Our ref: 26_36382_P

Your ref: H11-0755-26

Site Location: Adj. 73 Little London, Long Sutton,
Spalding, PE12 9LF

Summary of Proposal: Proposed Single
Storey Dwelling

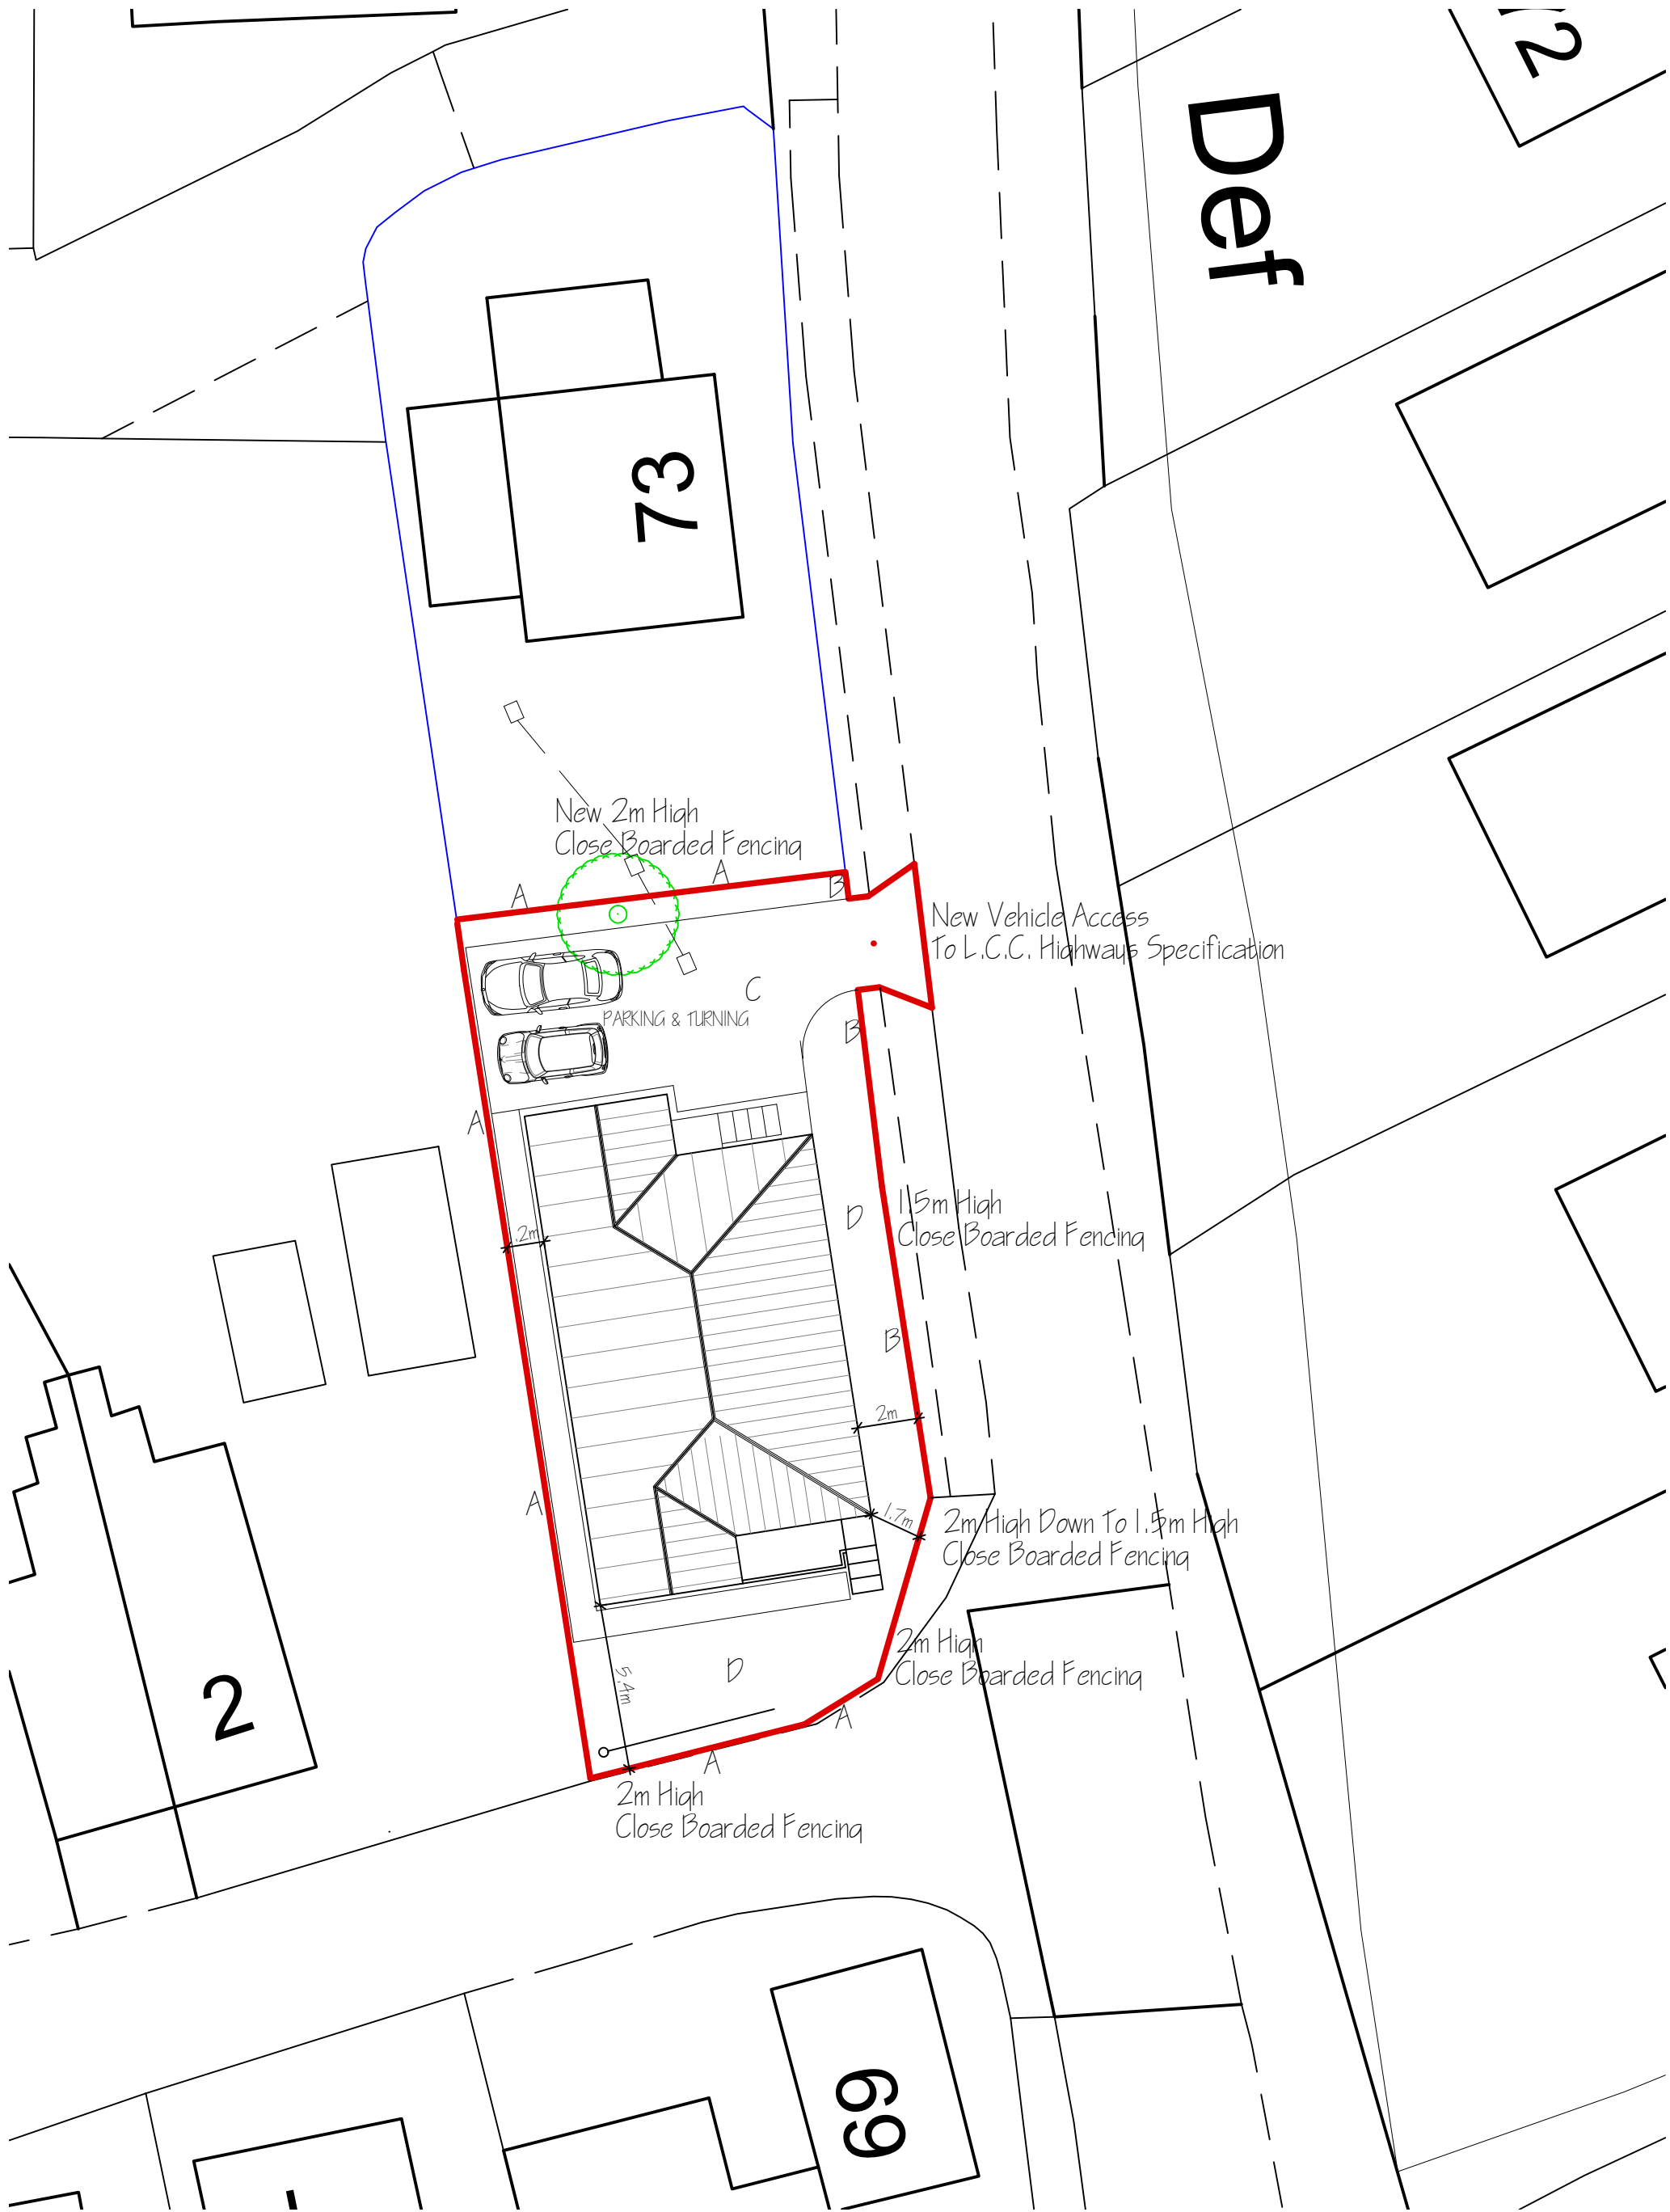
The applicant has indicated that they intend to dispose of surface water via infiltration, however we cannot see that the viability of this proposal has been evidenced. We recommend that ground investigation is carried out to determine infiltration potential, followed by testing in line with BRE Digest 365 if onsite material is considered favourable for infiltration.

If infiltration is not feasible at this site, following the drainage hierarchy we would expect the applicant to propose to discharge surface water to a watercourse, if feasible. In this case, consent would be required under Byelaw 3. The Board recommend that any discharge is in line with the [National standards for sustainable drainage systems \(SuDS\)](#) published in June 2025. Further to the National Standards for SuDS, the Board's policy is to restrict discharges to 2/l/s/ha or annual average flood flow rate (QBar or QMed), whichever is higher.
